Immingham Eastern Ro-Ro Terminal (“IERRT”)

PINS Ref: TR030007

**Deadline 3 submission of Associated Petroleum Terminals (Immingham) Limited
and Humber Oil Terminals Trustee Limited (referred to together as “the IOT Operators”)**

Comments on Responses to the Examining Authority’s First Written Questions (ExQ1)

Drawing title
GENERAL ARRANGEMENT PLANS RO-RO BERTHS & PROTECTION REGULATION 5(2)(o) & 5(2)(k) SHEET 1 OF 5

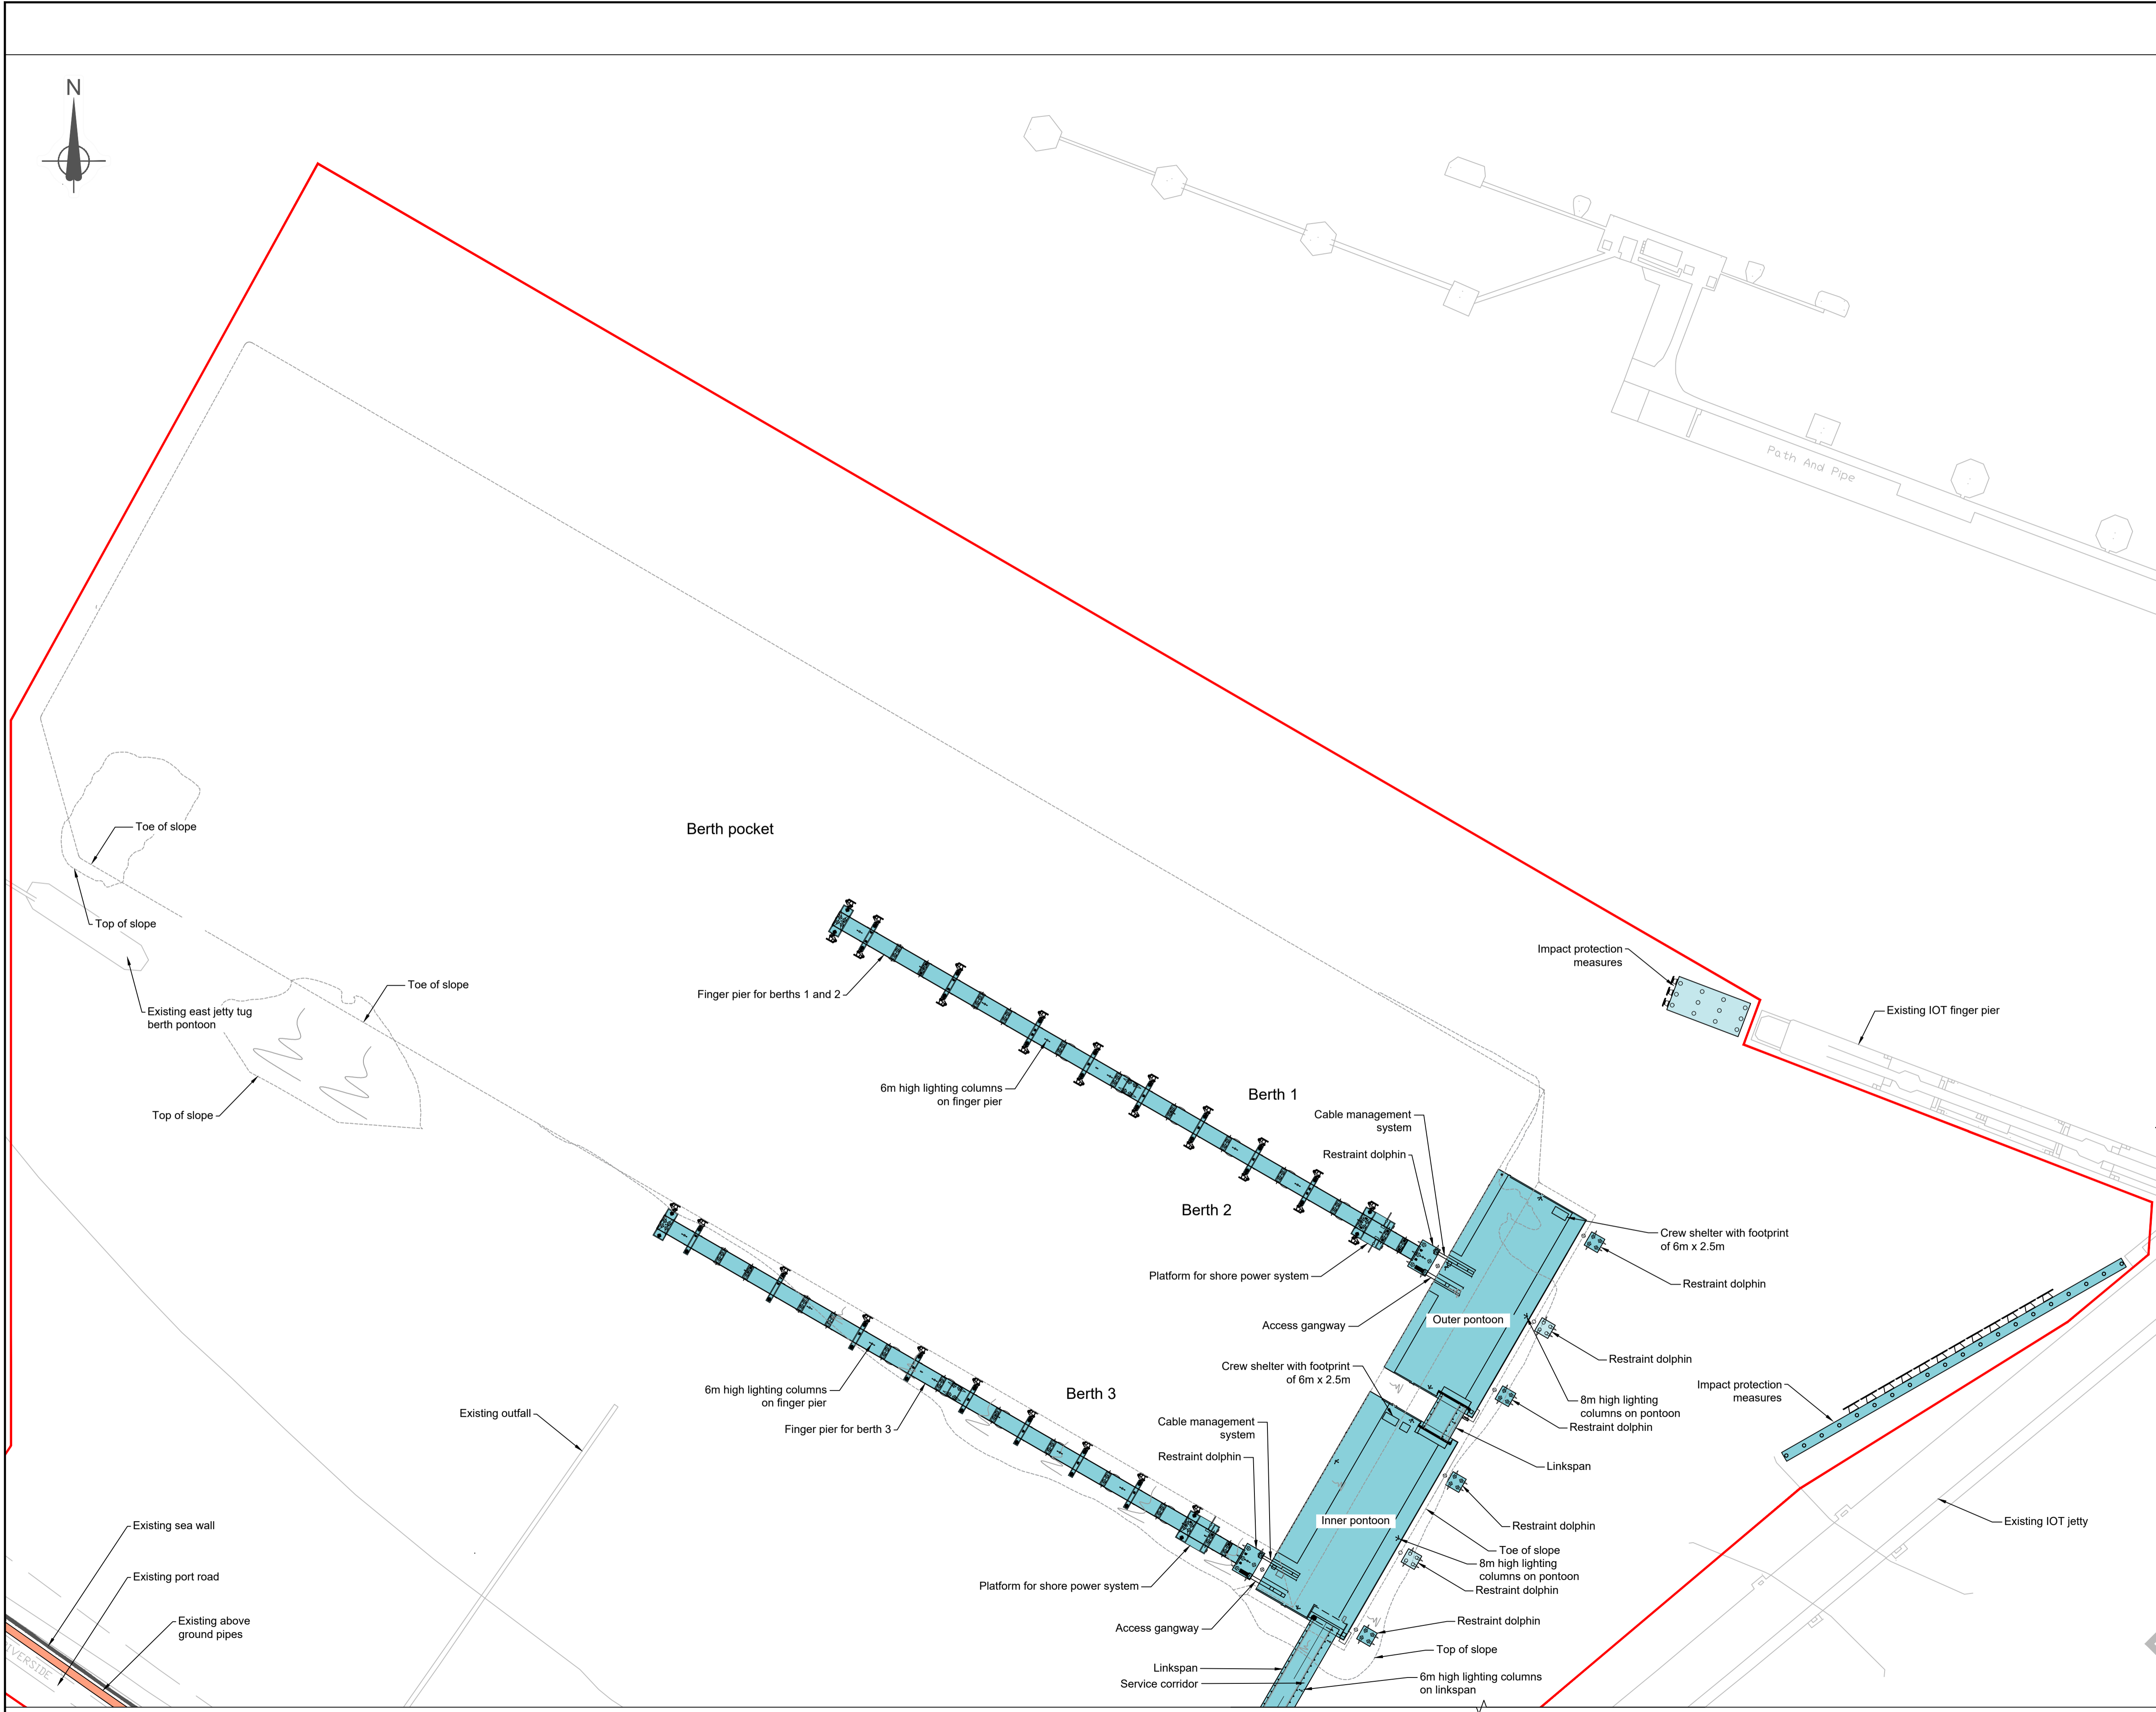
ExQ1	Response	Comments by the IOT Operators	
	<i>Associated British Ports</i>		
BGC 1.7	<p>Effects of construction of impact protection</p> <p>Paragraph 16.87 in [APP-052] of the ES refers to the construction of the proposed vessel impact protection measures being “timed to avoid works to the IOT finger pier berths 8 and 9 when they are in use”. Elaborate on that statement and provide an outline method statement for the</p>	<p>The Applicant provided a response to ISH2 Action Point 21 describing how the impact protection measures, if required, would fit into the construction programme for the IERRT.</p> <p>The Applicant’s assessments demonstrate and conclude that impact protection measures are not required. If, however, it was determined by the Applicant at some stage in the future that such measures should nevertheless be put in place, it is anticipated that the works would take place in line with the broad methodology provided below although a formal methodology would be prepared by the Principal Contractor appointed to undertake the works bearing in mind that both construction methodology and design may evolve with time.</p> <p>In brief, the piles would be installed with a piling gate on a floating/jack-up barge with a mounted crane. Each</p>	<p>The IOT Operators do not consider the impact protection (which is identified, but not proposed by the Applicant to be constructed) would be effective in preventing damage to the Immingham Oil Terminal (“IOT”). This is because no details have been provided by the Applicant on the ability of the impact protection structures to withstand an impact from an IERRT vessel travelling at 4 knots (the speed of an ebb tide at the IERRT).</p> <p>Further, no details have been given in relation to the IERRT infrastructure itself to withstand an impact by an IERRT vessel. Therefore, an errant IERRT vessel, travelling at 4 knots making contact with the IERRT infrastructure will result in the IERRT vessel and the IERRT pontoons becoming detached from the holding piles and then drifting onto the IOT Trunkway.</p>

<p>construction of the impact protection measures should it be determined they would be needed.</p>	<p>pile would be pitched into the gate using the crane and vibrated to refusal with a vibro-hammer. The pile will then be percussively hammered to reach final level.</p> <p>Following pile installation, in-situ pile plugs would be installed in each pile followed by the installation of pre-cast pile caps. The pile caps will support pre-cast concrete troughs/boxes which would be installed between each pile creating a longitudinal beam. Following this, in-situ reinforcement would be installed into the preformed beam, tied by an in situ concrete pour.</p> <p>The Environmental Statement Chapter 10 [APP-046] assesses the effects of construction occurring at the same time as the other marine and landside infrastructure, as well as construction occurring sequentially once the northern finger pier, with two berths is in operation.</p> <p>The process, if required would include liaison with the IOT Operators through the establishment of a Port Liaison Officer whose role will be to develop a marine liaison plan and ensure that vessel activity in the area is appropriately deconflicted through effective communication between VTS and the development contractors/operators. This is represented in the NRA [APP-089] in Annex B, Table B1, where there is an 'Applied Control' identified for a 'Port Liaison Officer' to be implemented by the Port of Immingham.</p>	<p>In order to investigate these issues the IOT Operators commissioned a report from highly reputable marine engineers - Beckett Rankine (BR) (see Appendix D of the IOT Operators' shadow Navigation Risk Assessment (sNRA) [REP2-064]), which determined that the impact force of an IERRT vessel would be in excess of 30 Mega Newtons (equivalent to approximately ~3,300 ton force).</p> <p>BR carried out a high-level review of the impact protection measures proposed by the Applicant and documented the following concerns:</p> <ul style="list-style-type: none"> • The protection system is shown remarkably close to the existing terminal infrastructure which leaves little margin for deflection of the protection structure. Also, vessel overhangs may over-ride the protection structure with a risk of contacting the IOT pipework. • The proposed location does not protect the IOT Finger Pier for berths 6 to 9 from vessel impact. • The system appears under designed considering the tidal conditions and the potential magnitude of the impact. Although, it should be noted, a detailed calculation check has not been undertaken and the type of fender system is not defined. <p>As a result, BR identified that piles would need to be in the order of 2.8m diameter (nearly three times the diameter proposed by the</p>

<p>Applicant) - and located upstream of the IOT Finger Pier.</p> <p>The IOT Operators are therefore concerned that as the design and location of the impact protection measures are inadequate to mitigate impact by IERRT vessels, then the actual impact to IOT operations as a result of its construction cannot be determined with any degree of certainty. Therefore, the IOT Operators consider it necessary to impose a requirement on the Applicant that construction of the impact protection cannot impact any day to day operations of the IOT Finger Pier.</p> <p>The IOT Operators note that the Applicant will <u>if required</u> establish a Port Liaison Officer role, who will liaise with the IOT Operators and develop a Marine and Liaison Plan. It is not clear how the Applicant will establish the need for the role, or the extent to which the IOT Operators will be consulted on the development of the Marine and Liaison Plan, or indeed whether the IOT Operators are able to review and approve any plan.</p>

<p>BGC 1.14</p>	<p>Impact protection measures for the Immingham Oil Terminal (IOT)</p> <p>Should the CEMP [APP-111] include wording in the tables of mitigation measures, most particularly Table 3.4,</p>	<p>The Applicant does not consider that the potential construction of impact protection measures should be included in the CEMP.</p> <p>The principal purpose of a CEMP is to explain how an Applicant or developer will minimise any potential negative environmental impacts that may arise during the construction phase of the project.</p> <p>As the ExA is aware, the Applicant is of the view that impact protection measures are not, in any case,</p>	<p>The IOT Operators’ sNRA [REP2-064] has confirmed (through qualitative (Section 9) and quantitative assessment (Section 10) incorporating transparent Cost Benefit Analysis (Section 12)) that impact protection measures are necessary, and also that the design as presented by the Applicant is not sufficient to arrest an errant IERRT vessel (Appendix D of the sNRA).</p>

NS 1.12	<p>Reducing Risk of Allision with IOT trunkway to ALARP</p> <p>Is it correct that the submitted NRA [APP-089] states that the implementation of</p>	<p>No, that is not correct. The NRA [APP-089] has concluded that impact protection measures for the IOT trunk way are not required to meet the ALARP required condition.</p> <p>The comment that is being referenced underlines, what is considered to be the good practice adopted by the Applicant, namely that the NRA faithfully records and</p>	<p>The IOT Operators do not consider the impact protection would be effective at withstanding an impact from an IERRT vessel travelling at 4 knots (the speed of an ebb tide at the IERRT). This point is also addressed in response to BGC 1.7.</p>

<p>impact protection measures for the IOT trunkway, proposed Work Number 3, as additional mitigation for allision risk would be necessary to control the risk of allision with the trunkway to attain “as low as possible reasonably practicable” (ALARP)?</p>	<p>takes into account the comments of the Interested Parties who attended the HAZID workshops and who made the suggestions – even though those suggestions may not be reflective of reality.</p> <p>It would have been wrong for the Applicant to have failed to have presented a balanced record of the comments received by the Interested Parties during those Workshops – even though some may have been influenced by the wish to protect their own commercial interests - from the generality of the formulation of the NRA.</p> <p>The Applicant’s position remains, however, as stated above.</p>	<p>The IOT Operators’ sNRA [REP2-064] has confirmed (through qualitative (Section 9) and quantitative assessment (Section 10) incorporating transparent Cost Benefit Analysis (Section 12)) that appropriately designed impact protection is necessary to mitigate intolerable risk to acceptable levels through use of ALARP.</p> <p>The IOT Operators do not agree that the Applicant’s NRA [APP-089] is sufficiently robust and detailed to conclude that impact protection is not required due to allision hazards being ALARP as:</p> <ul style="list-style-type: none"> • No “standards of acceptability”, as required by the PMSC (see [REP1-015] section 2.7), have been provided by the Applicant in their NRA so it is not possible to determine whether hazards are acceptable or not. • Only two additional risk control measure are proposed by the Applicant to mitigate the risk of IERRT vessel contacting the Trunkway (see summary in Table 21 of the IOT Operators’ sNRA [REP2-064]): <ul style="list-style-type: none"> ○ ABPmer RC1: Berthing criteria – although no berthing criteria are specified so the effectiveness is therefore unknown. ○ ABPmer RC2: Additional pilotage training/ familiarisation - which is considered by the IOT Operators to be an embedded control, otherwise attendees at

<p>the hazard workshops should have been informed that pilots / PEC's wouldn't be trained properly to visit the IERRT.</p> <ul style="list-style-type: none"> • No details of any Cost Benefit Analysis is provided in the Applicant's NRA (e.g. details on the cost of the proposed impact protection or design parameters). • The Applicant's NRA methodology for likelihood uses qualitative descriptors and not mathematical probabilities. As such it is not clear how the cost benefit of a risk control measure, which is needed to determine ALARP, such as impact protection can be referenced to a reduction in hazard likelihood based on whether it is very rarely / might / could / quite likely / will occur.
NS 1.13	<p>Decision process flow for implementation of Impact Protection to IOT</p> <p>Provide a note with a flow-diagram explaining the process for determining whether or not impact protection measures for the Immingham Oil Terminal would be installed. The</p>	<p>The draft DCO at Requirement 18, provides that if the Statutory Conservancy and Navigation Authority (effectively the Harbour Master Humber) considers that that the provision of impact protection measures may be necessary, then the "Company" i.e., the Applicant must give that recommendation "due consideration".</p> <p>The process for the Applicant's "due consideration" is outlined in the Note provided as REP1-014. In simple terms, however, bearing in mind that as noted, the Applicant does not consider that this scenario will actually arise, the process will involve the compilation of relevant assessments/reports followed by consideration of the recommendation – which of itself will have to be supported by explanatory data. The ultimate decision</p>	<p>The IOT Operators note that the impact protection as proposed by the Applicant resides within the Statutory Harbour Authority of the Port of Immingham and therefore falls outside the jurisdiction of the Harbour Master Humber who works for ABP Humber Estuary Services.</p> <p>The IOT Operators note the Applicant's approach to whether the impact protection is needed would "<i>involve the compilation of relevant assessments/reports</i>". The IOT Operators requires that these assessments/reports to be completed as soon as possible and submitted to the IERRT DCO Examination. The reports should:</p>
